Academy Street Development, Navan,  
Co. Meath

Quality Audit

<b>Document Ref:</b>	<b>P19-106-RP-001</b>
----------------------	-----------------------

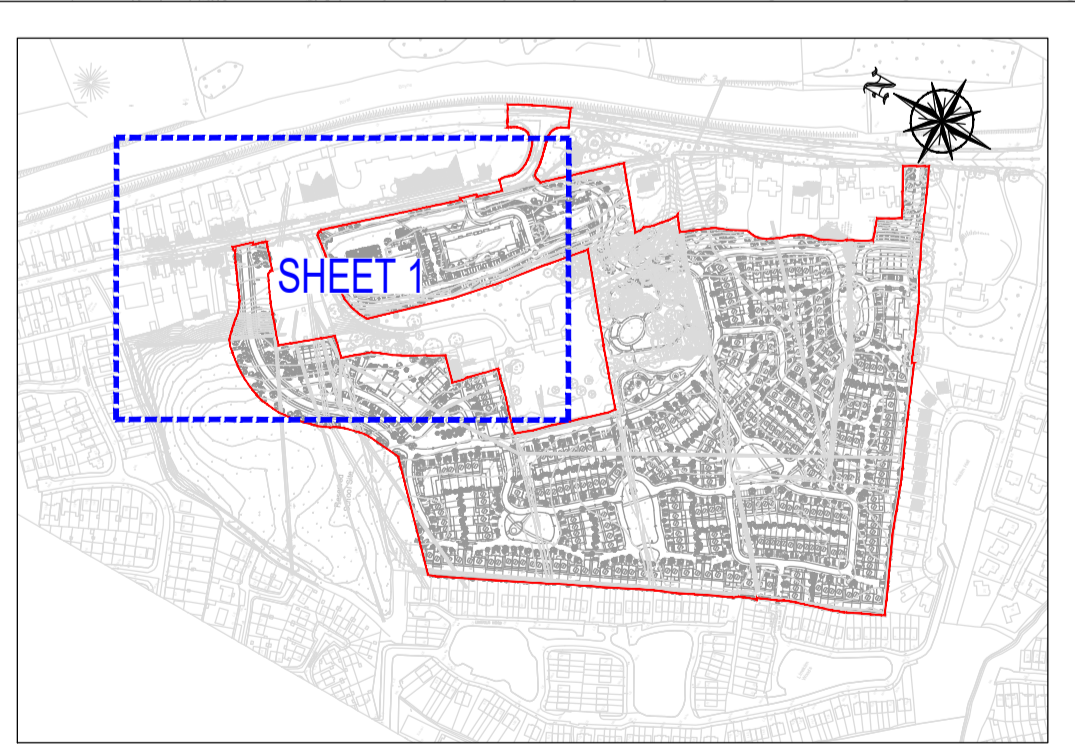
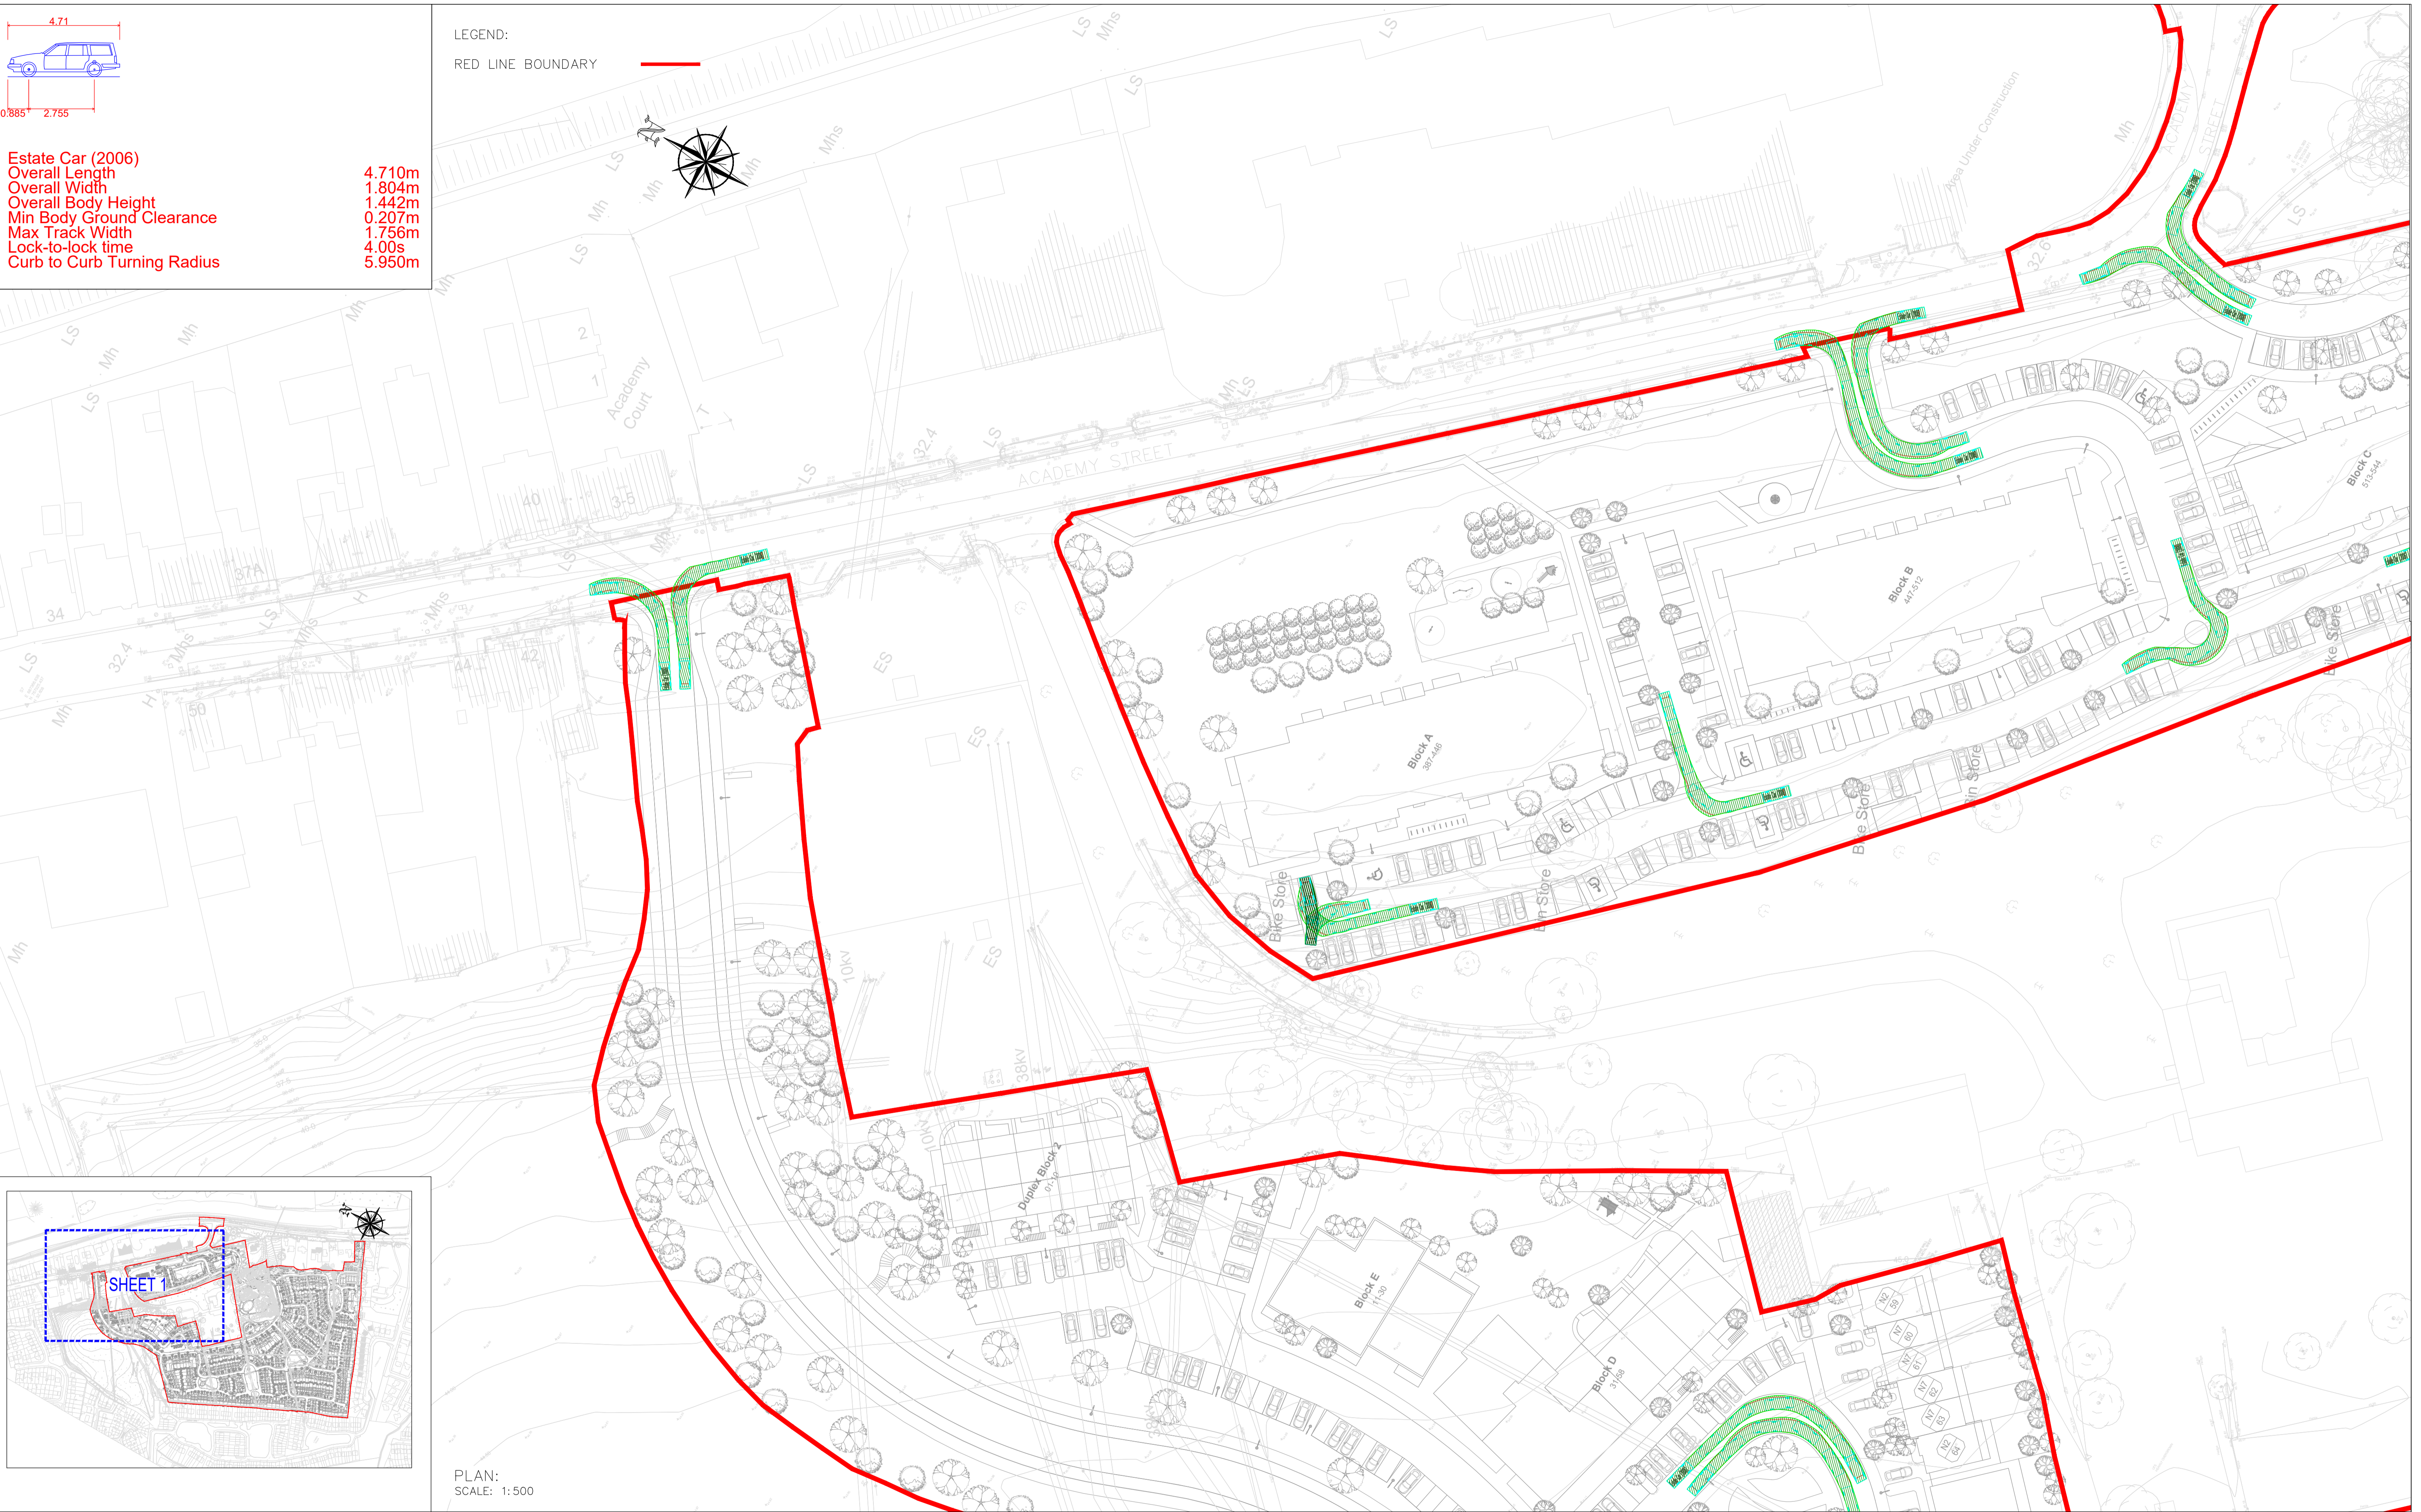
Summary: *It is unclear if there is sufficient swept path for vehicles entering/exiting parking spaces throughout the scheme.*

There are a number of locations throughout the scheme where insufficient swept path may be provided to vehicles entering/exiting parking spaces. This may result in vehicles having to undertake complex turning manoeuvres to access the parking spaces, leading to material damage collisions.

Swept path analysis should be undertaken to ensure sufficient turning space is provided to all car parking spaces. Where necessary, the layout should be adjusted to accommodate swept path.
